Application No: AL/85/21/PL
Site Address: Norton Farm House Norton Lane Norton PO20 3NH
Description of works: Subdivision of existing building to create 2 bedroom dwelling, construction of detached garage/workshop, external & boundary works. This application affects the setting of a listed building, affects the Norton Lane/Norton Conservation Area & is in CIL Zone 3 & CIL Liable as new dwelling.

Thank you for your internet representation made on 5th August 2021 which has been recorded as an objection with the comments as follows:

CLIENT
MR AND MRS R HOMER
 PROJECT
NORTON FARMHOUSE
GARAGE AND WORKSHOP
 DRAWING TITLE
ELEVATIONS AND SECTION
 SCALE
1/50 at A3
 REFERENCE
11913.07B

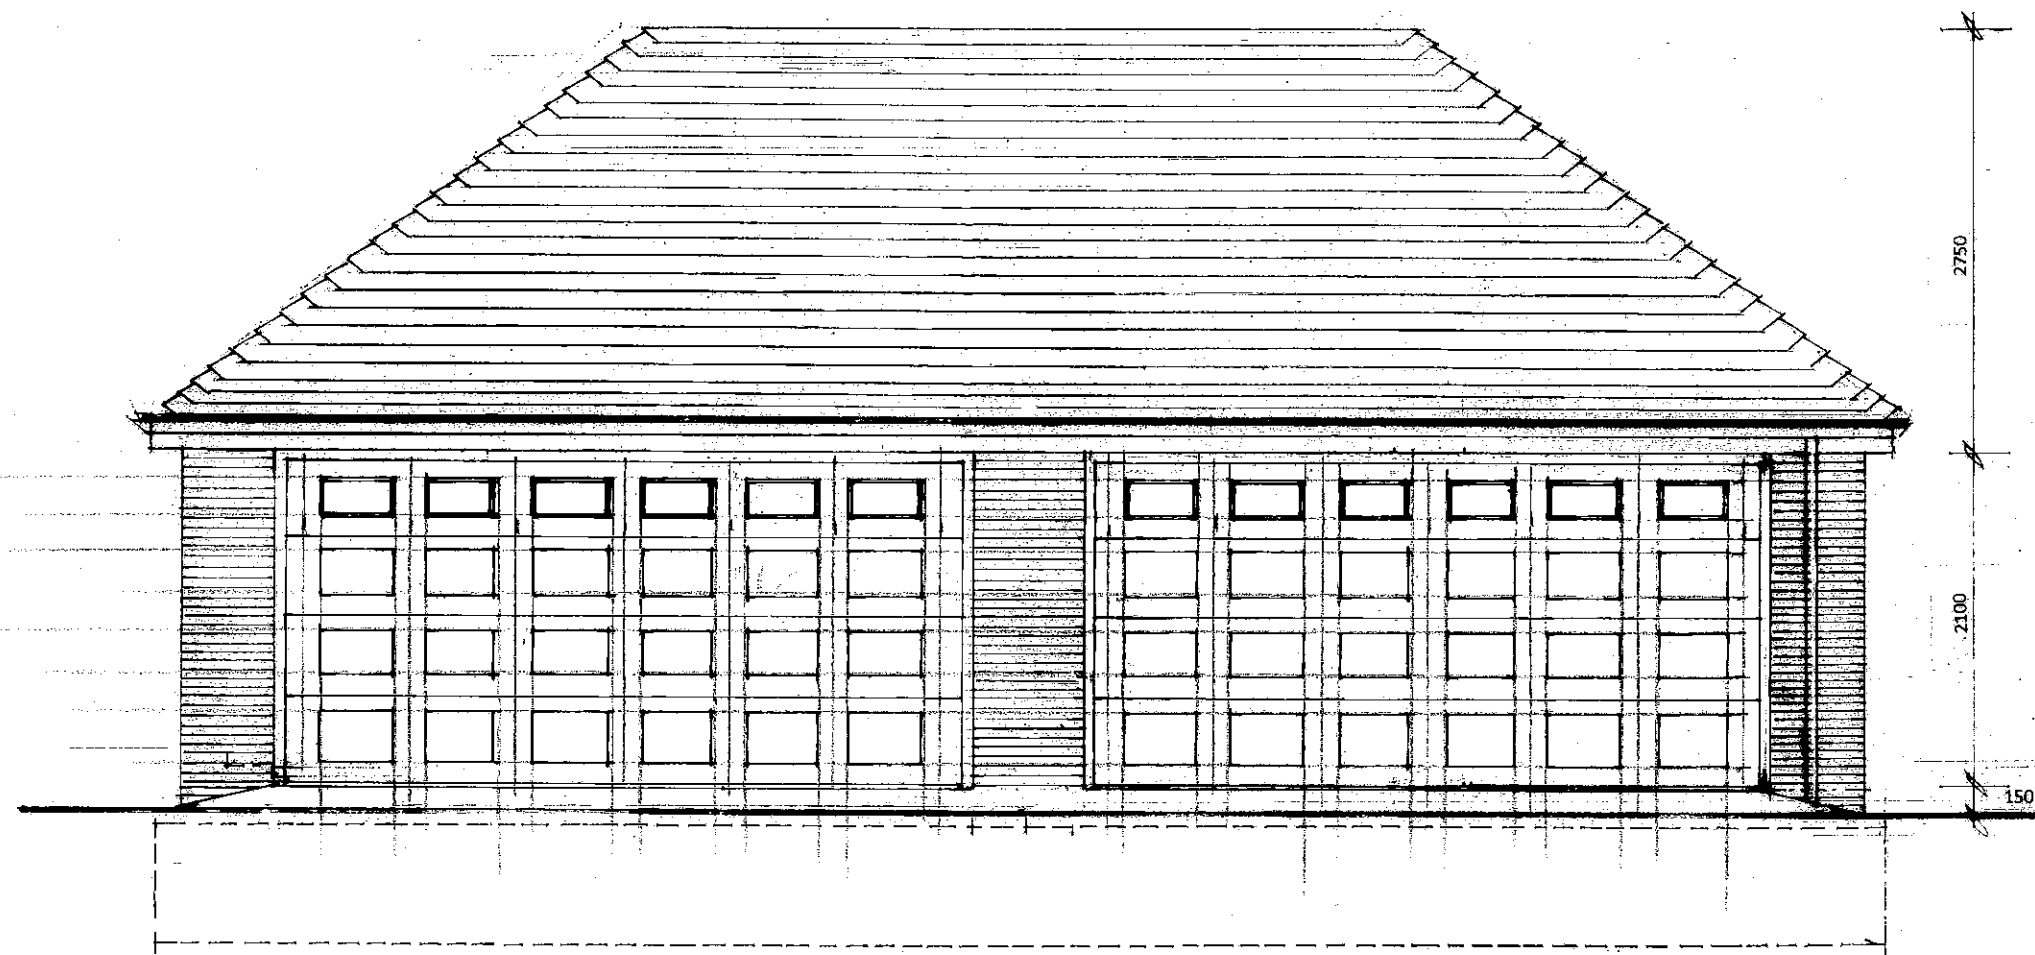
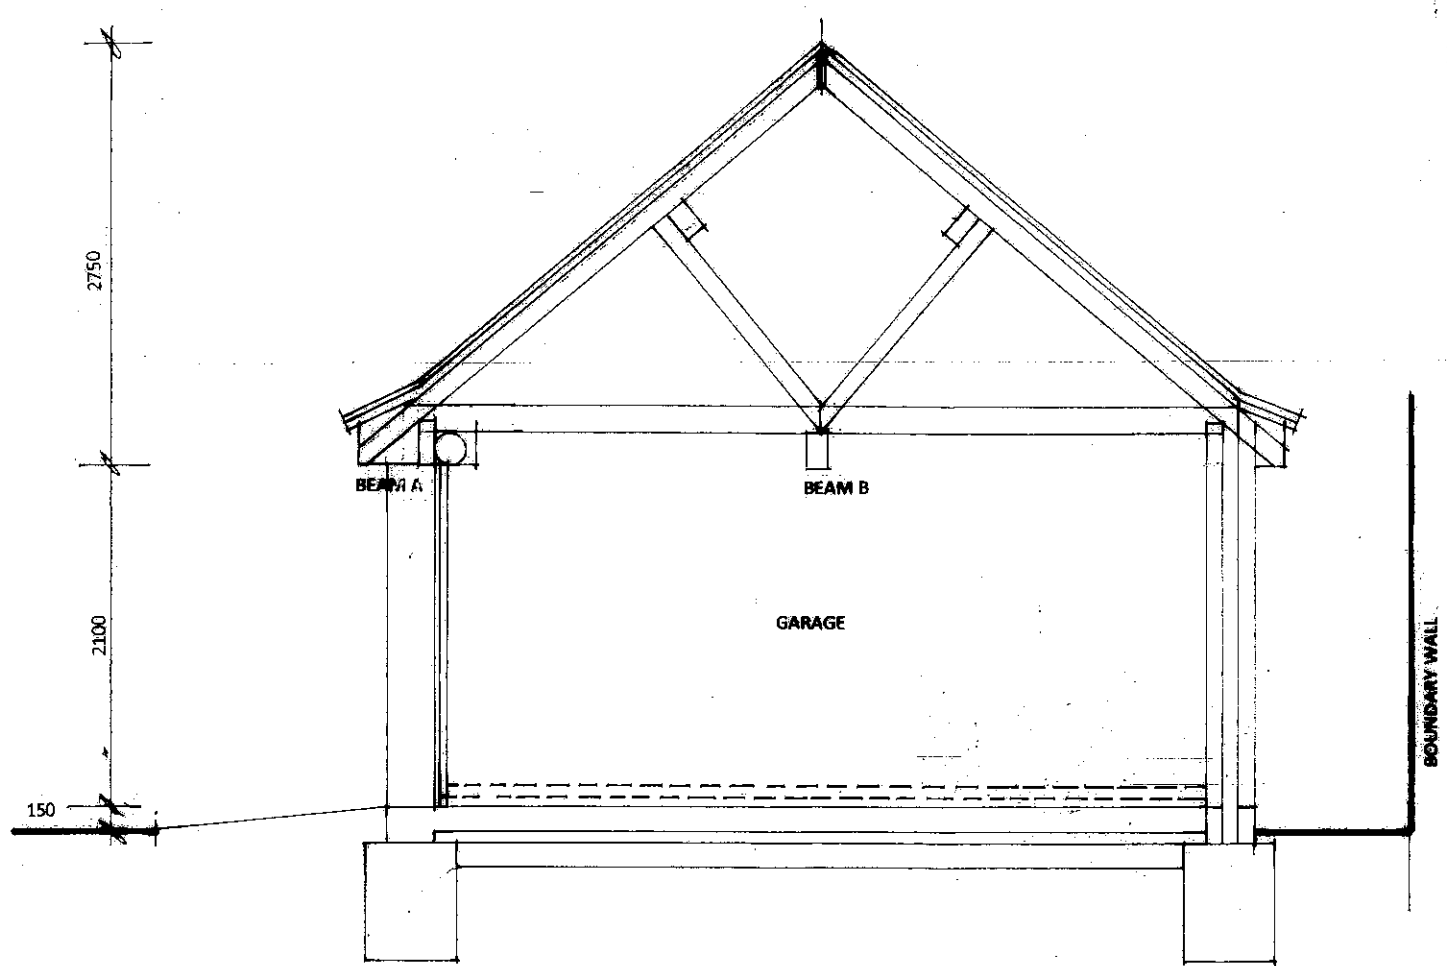
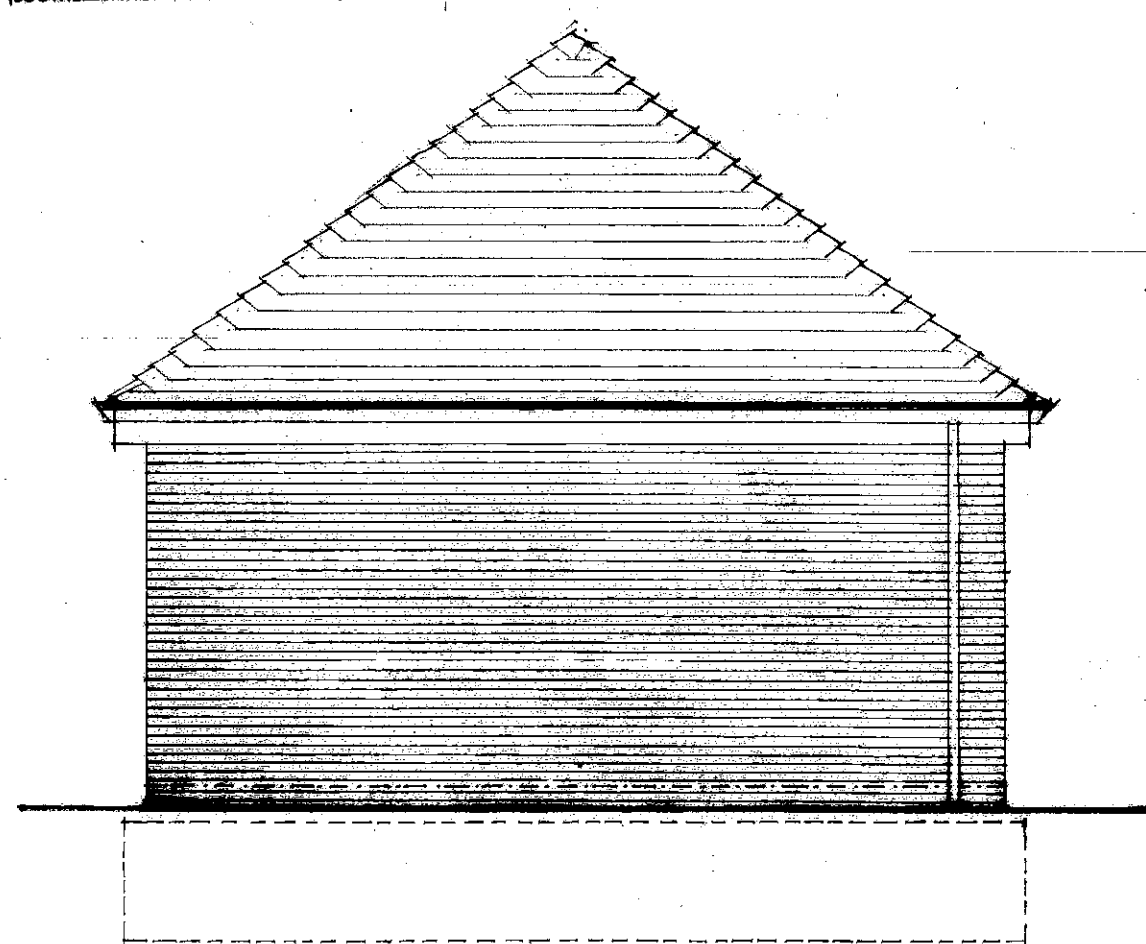
4. Boundary treatments are more akin to a housing development not suitable in a Conservation Area in the grounds of a listed building.
5. The description of the new carport doesn't show its height in relation to the existing buildings, it should be subservient to the existing building. The plans to the application of AL/34/20/PL hoodwinked the Council into believing it was to be subservient to existing buildings. There was a measurement shown but as the plan depicted the new carport to be lower the Council didn't check the measurements. These new plans somehow cut off the adjacent building, why has this been done when the first set of plans (AL/34/20/PL) clearly showed the height of the existing building next door, could it be to mislead Arun District Council again, I do not know? Arun District Council please check measurements as these plans do not show the whole story. None of the

plans show this garage in relation to the other buildings on Old Dairy Lane either.

LOCATION PLAN AND BLOCK PLAN

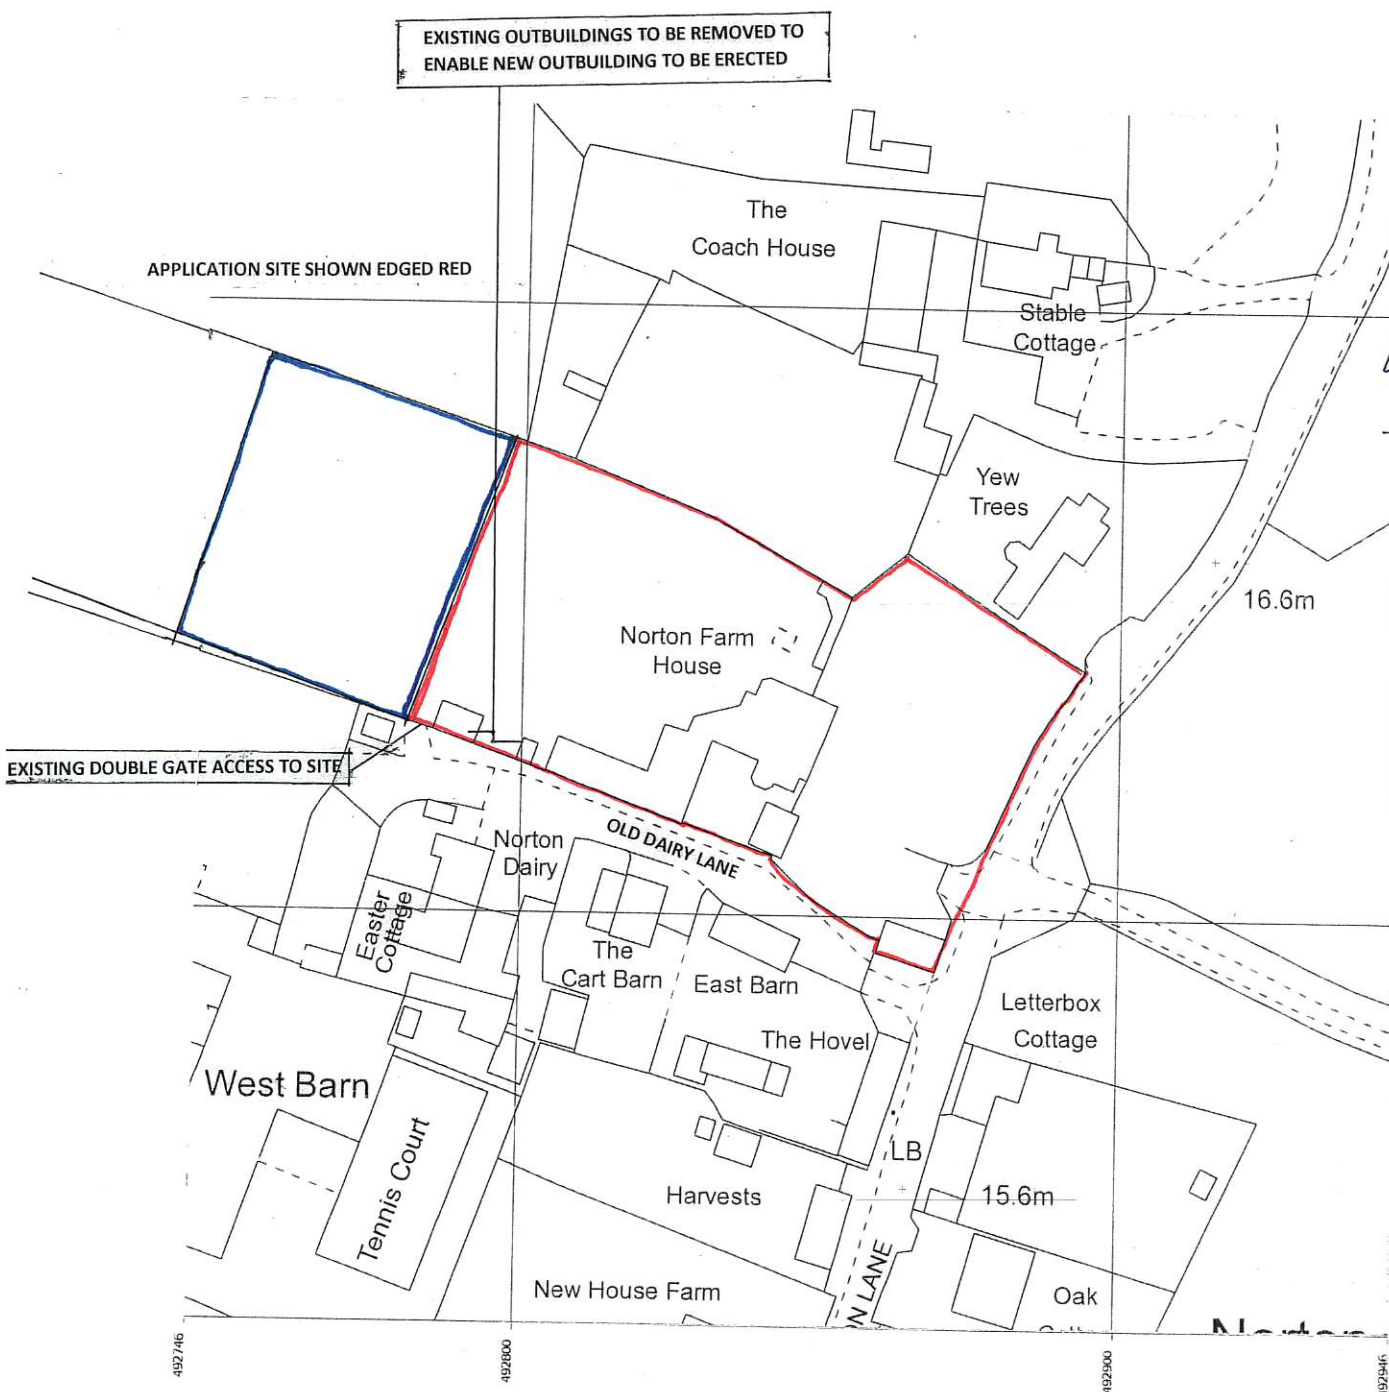
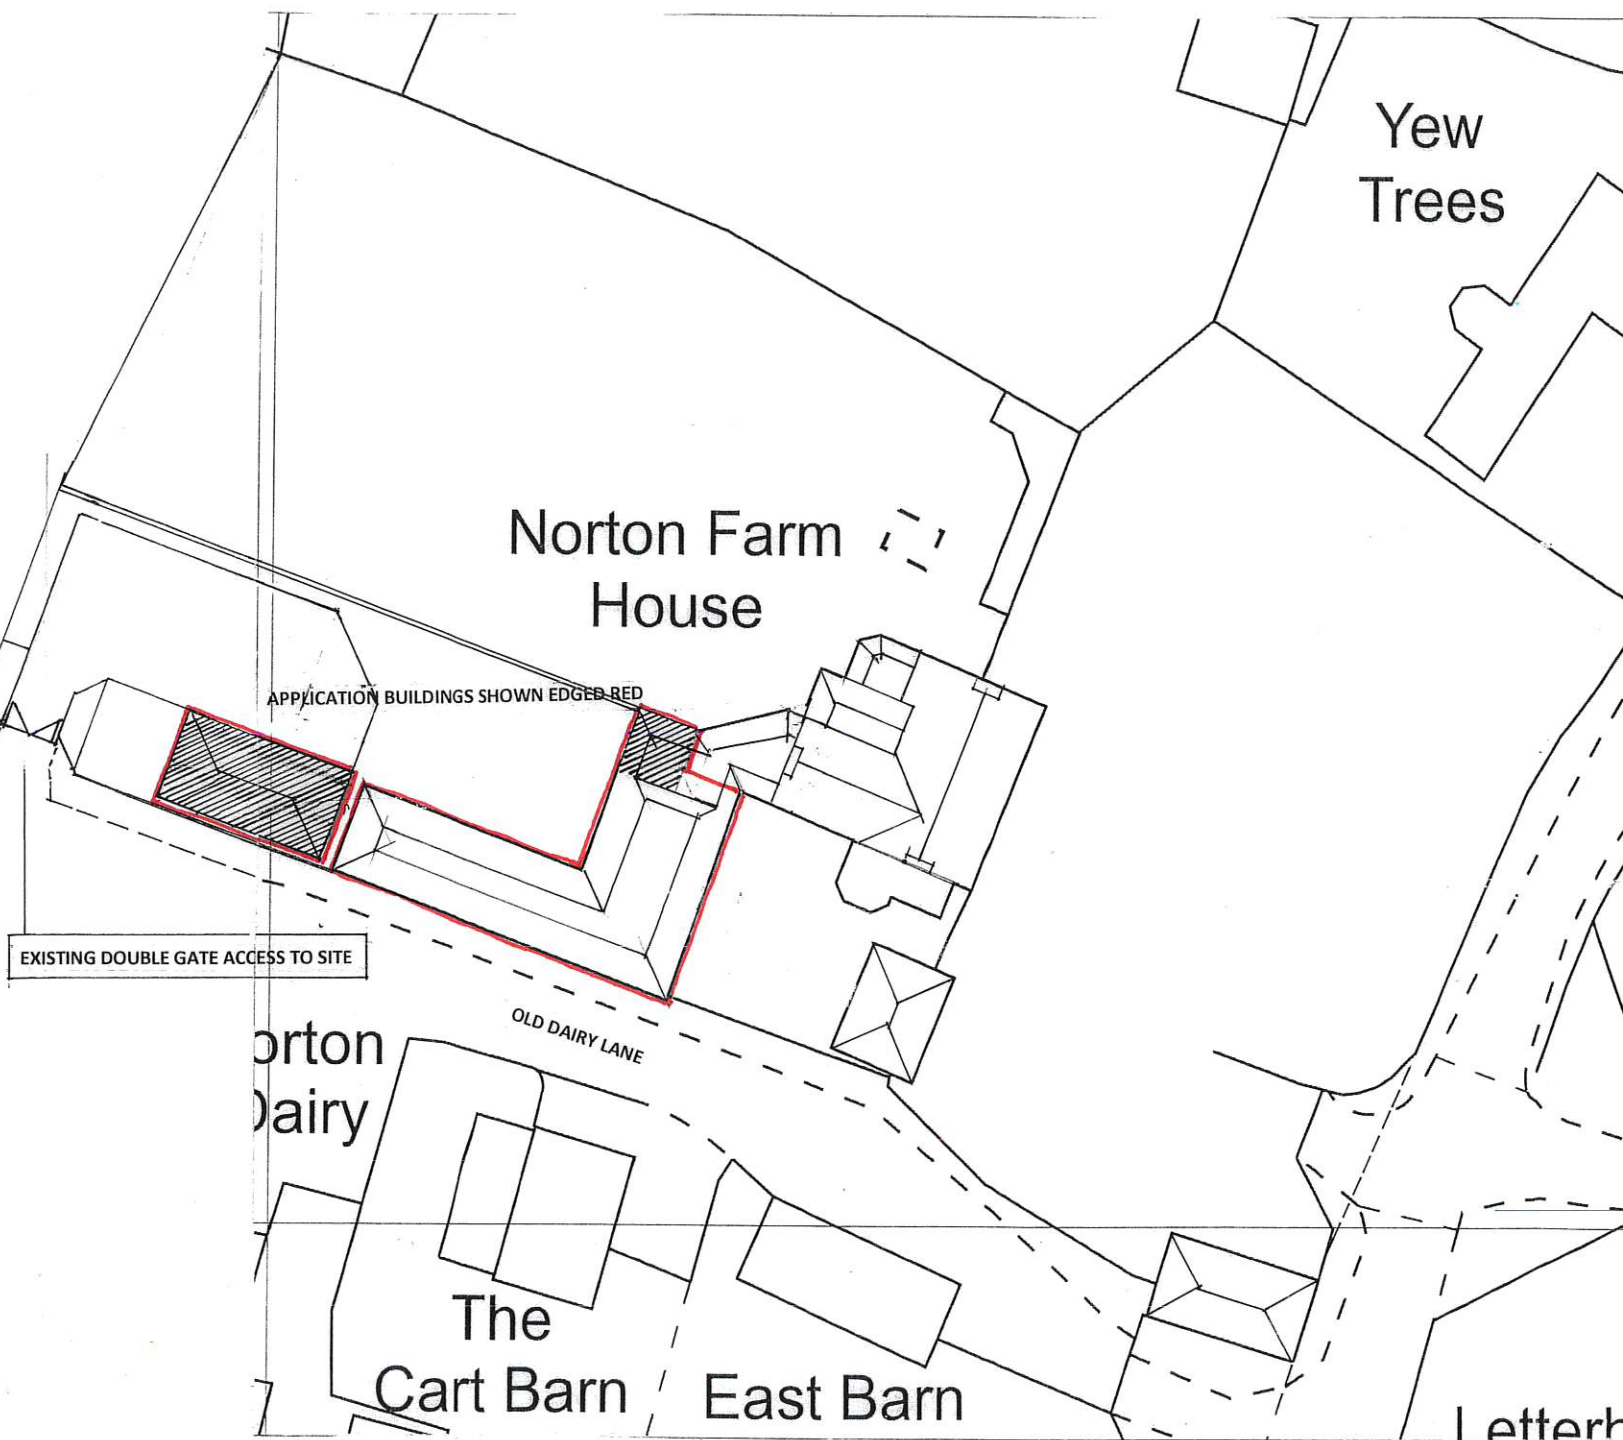
3. The location and block plans do not show the extent of the applicants' land ownership, there is the small area outlined in blue which the concrete base is on but further to the west the applicant owns the rest of the field. This may be a ruse to include this into the curtilage. The blue line should extend showing the whole field not part of.
